Subject: FW: D3.2017.0857 Lowood Whins Lane, Read BB12 7RB

Planning Application No: 3/2017/0857
Grid Ref: 376673 435074
Proposal: Application for Outline Planning Permission for two dwellings including access (all other matters reserved).
Location: Lowood Whins Lane Read BB12 7RB

FIGURE 1
PROPOSED CENTRELINE OF HIGHWAY ACCESS & VISIBILITY SPLAYS FOR 2 DWELLINGS ONTO WHINS LANE, READ (AT LOWOOD)

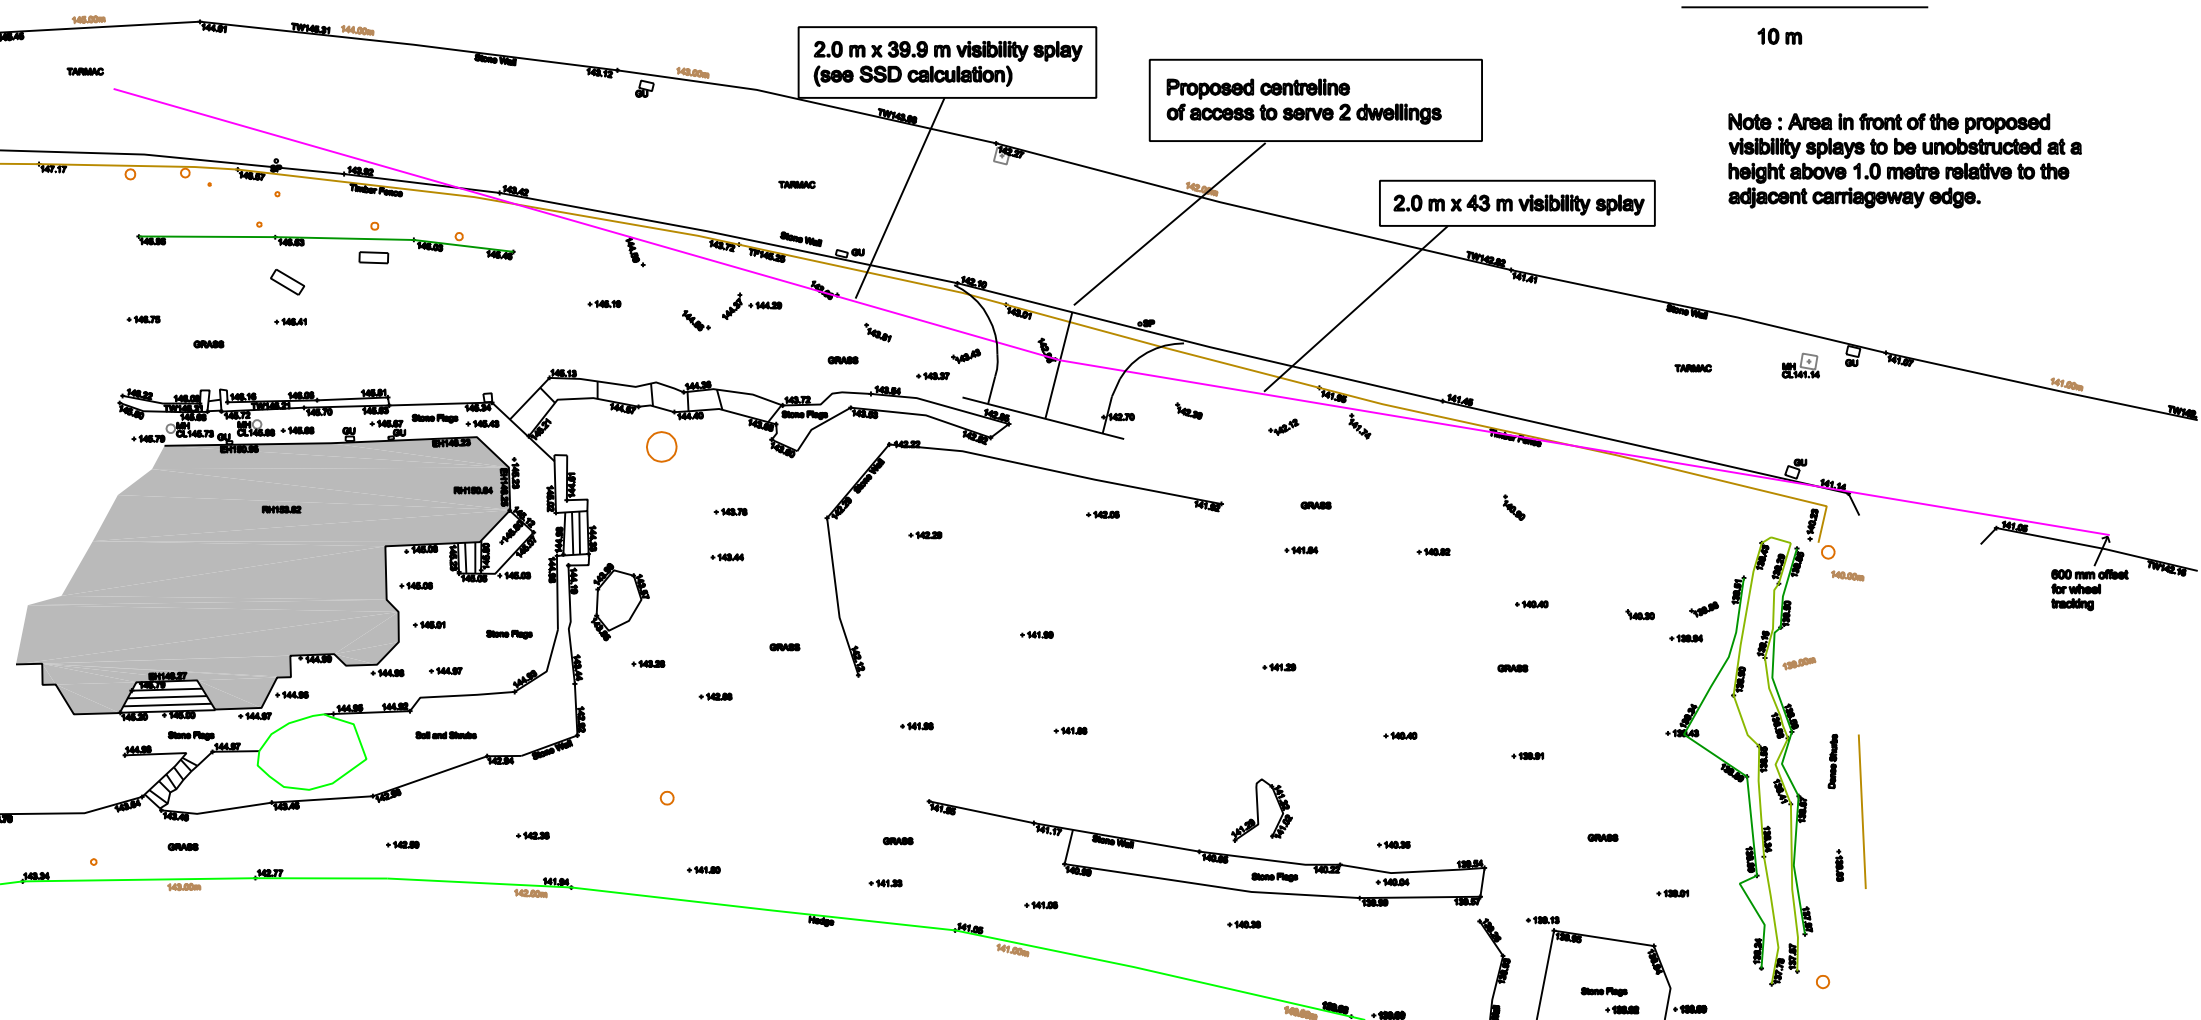
With regard to the above application. Thank you for the additional information that indicates that the applicant has addressed the concerns that I raised in my earlier comments. As this is the case I would remove my concerns with regard to the sightlines at the access point of the development. This being the case I would not be raising any objections to the development on highway grounds subject to the conditions and notes listed in my earlier comments dated 22nd September 2017 being attached to or addressed in any permissions that your council is minded to grant.

Please find attached the amended plans/info in response to your initial objection.
